16/07/2020

**Darlington Public School Redevelopment (SSD-9914)  
Request for Response to Submissions**

Tree management plan

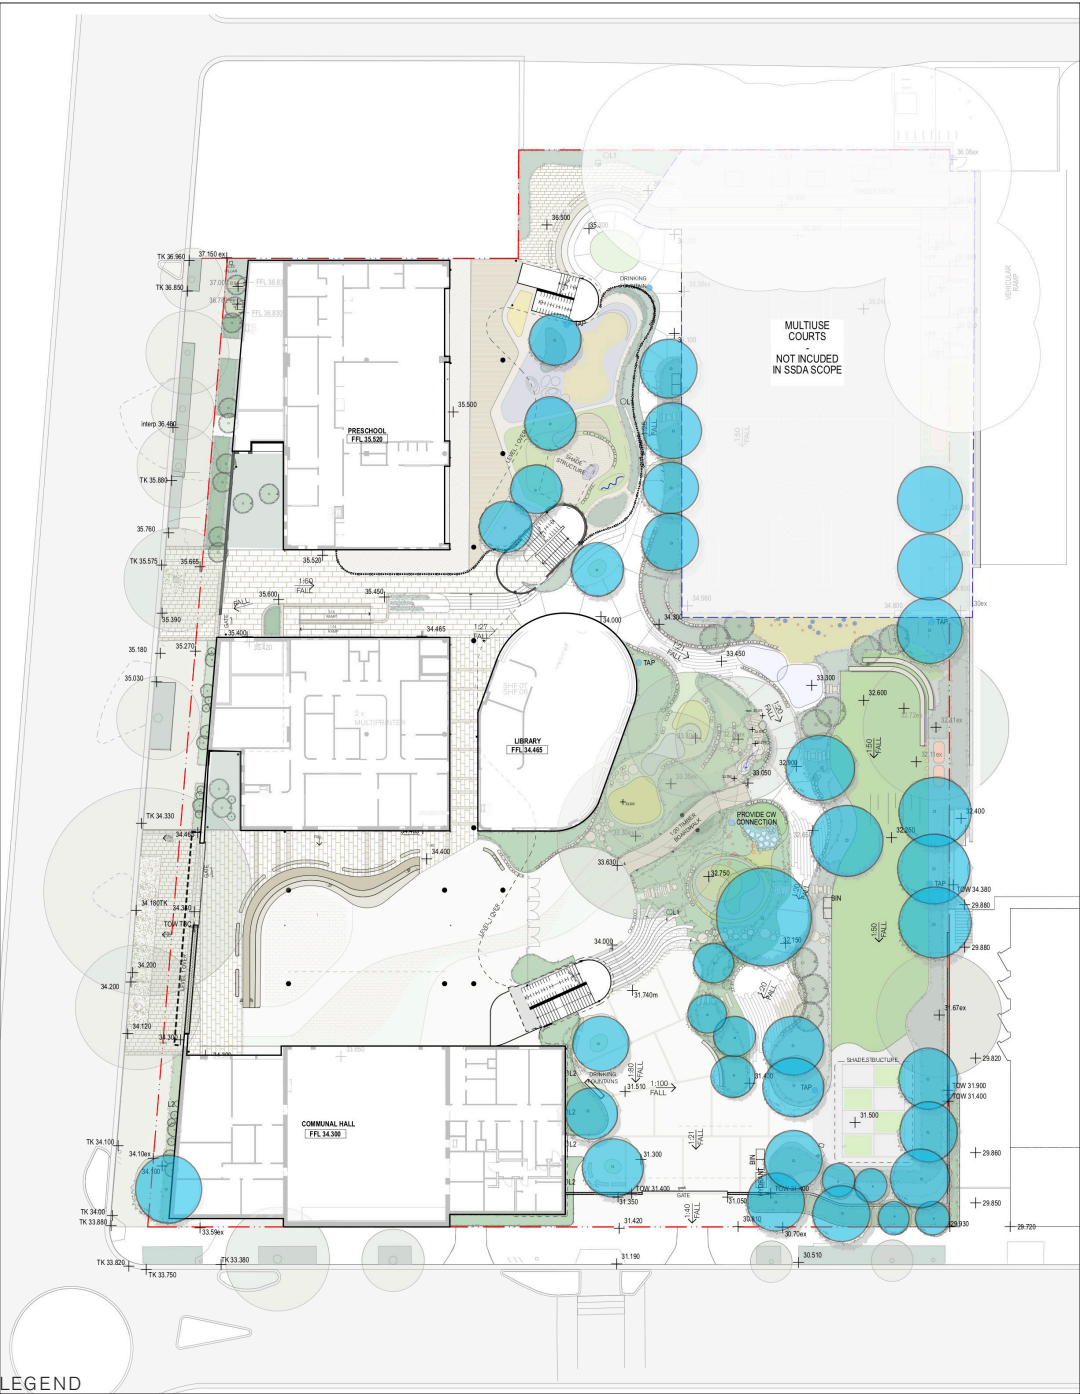
- Clarify the number of trees to be removed and correct inconsistencies between the EIS report, Arborist Report, Landscape Report and submitted plans.
- Provide an updated Arborist Report (including Appendix 2) that:

- Provide an updated planting schedule that includes the proposed numbers of each tree species to be planted and details of height / canopy spread at maturity.

- Provide information to justify the proposed landscaping and tree planting having regard to the Greener Places Design Guide (Government Architect NSW) urban tree canopy cover and including details on the pre-development and post-development tree canopy coverage on-site.

5.0 BICYCLE STORAGE

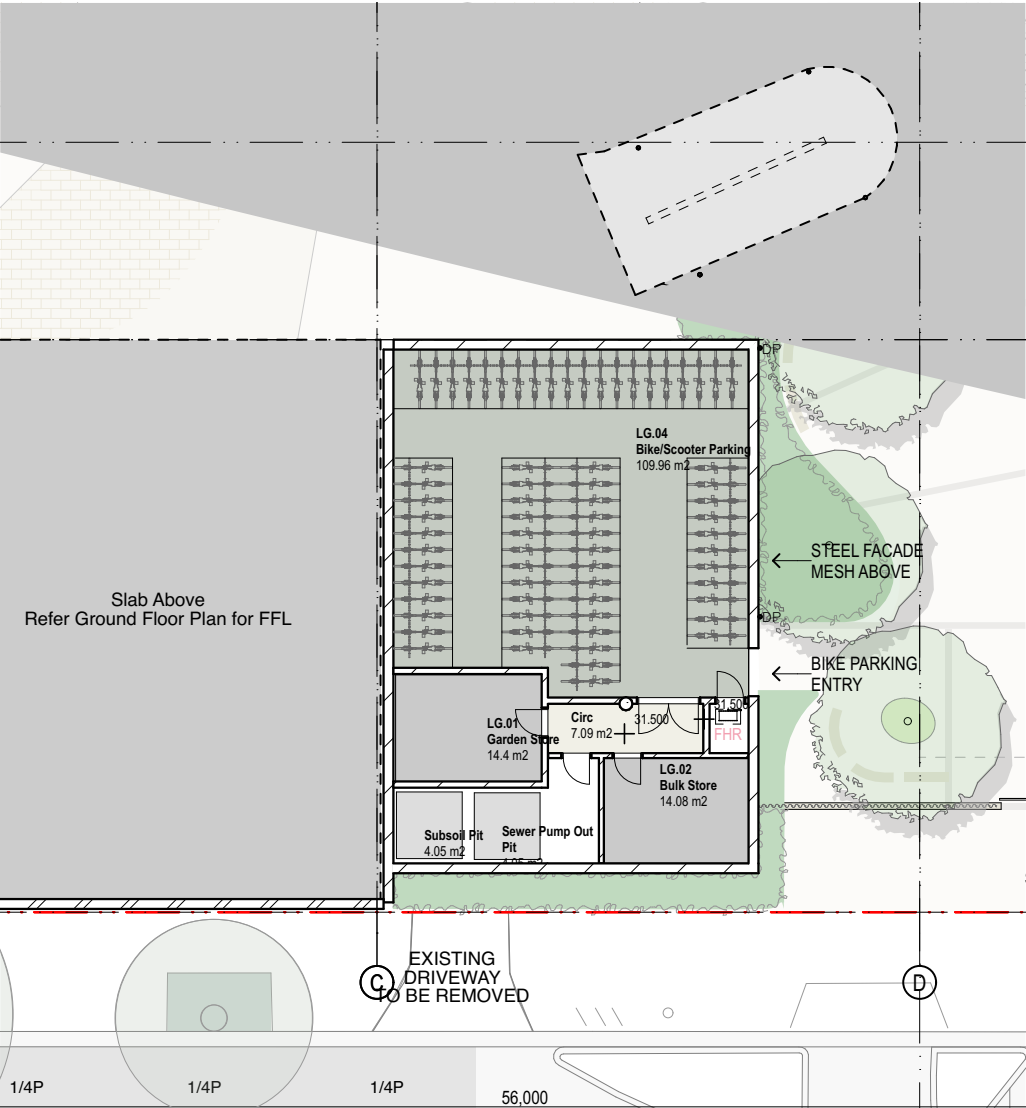
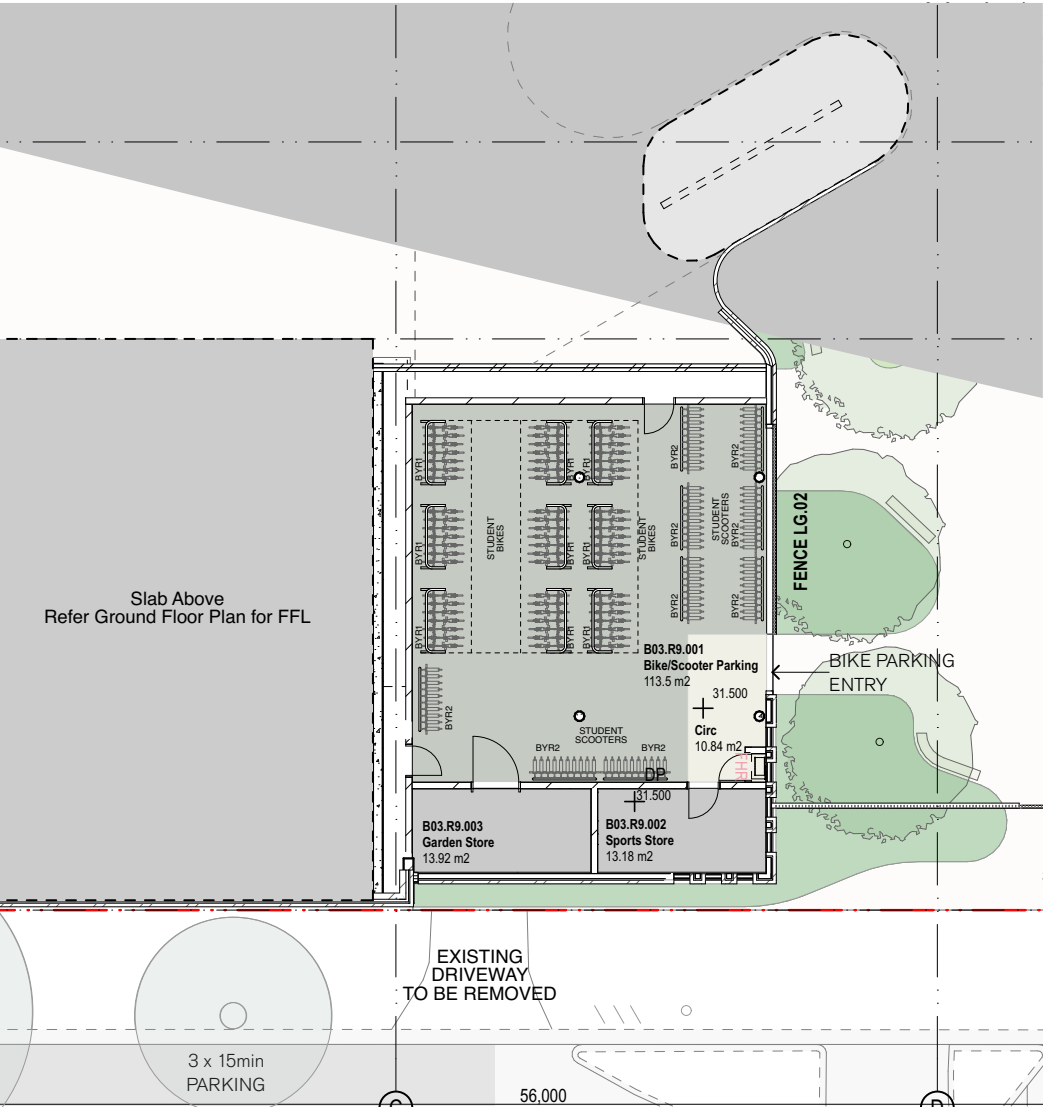
- Consideration should be given to increasing the number of bicycle / scooter parking spaces to be provided to accommodate the larger student population, given the:
  - Traffic Impact Assessment states that almost 30% of the existing students ride to school.
  - proposal as submitted includes the provision of 67 bicycle / scooter parking spaces.
- Provide details relating to the number and location of lockers to be provided for staff use.
